From: Martyn White
Sent: 12 May 2014 12:36
To: Anita Gardner
Subject: M/14/14

**ADC Planning Consultation
Response from the Conservation Officer**

Application Number	M/14/14
Address	Telephone Exchange 3-5 Elmer Road Middleton on Sea PO22 6DZ
Description	Replace 7 No wooden windows with PVCu to match existing style.
Case Officer	Mrs Gardner

Technical drawings below showing cross sections of the Evolve VS window.

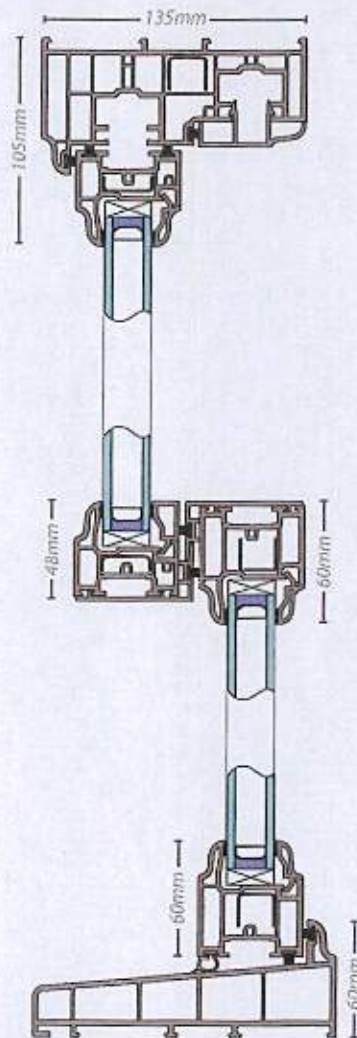
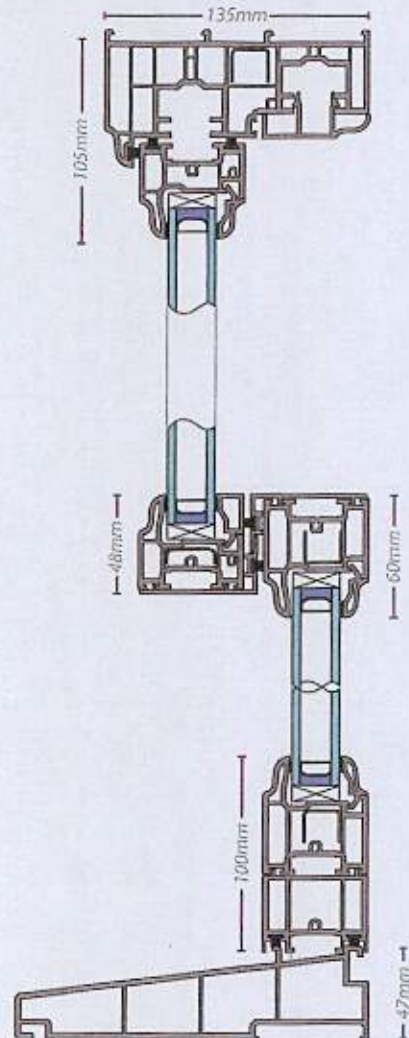
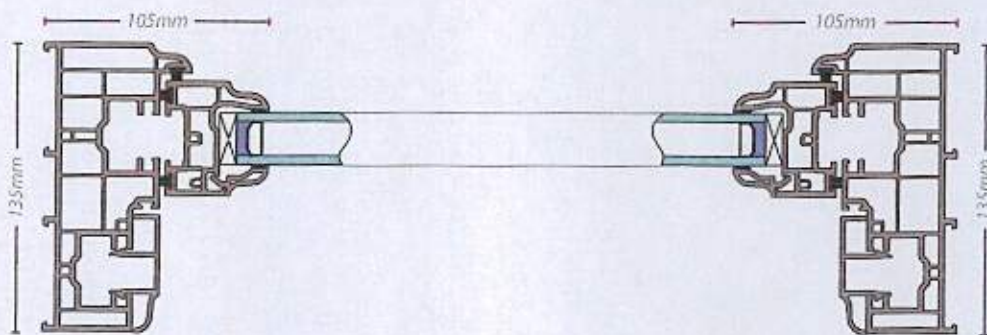
It is considered that the replacement plastic windows fail to match the appearance of the existing units: they will have larger, heavier sections than the existing timber windows and the black rubber gaskets will become visible around the glass. In addition, the method of opening is also in contrast to the existing which, as already mentioned is an inappropriate method for providing ventilation.
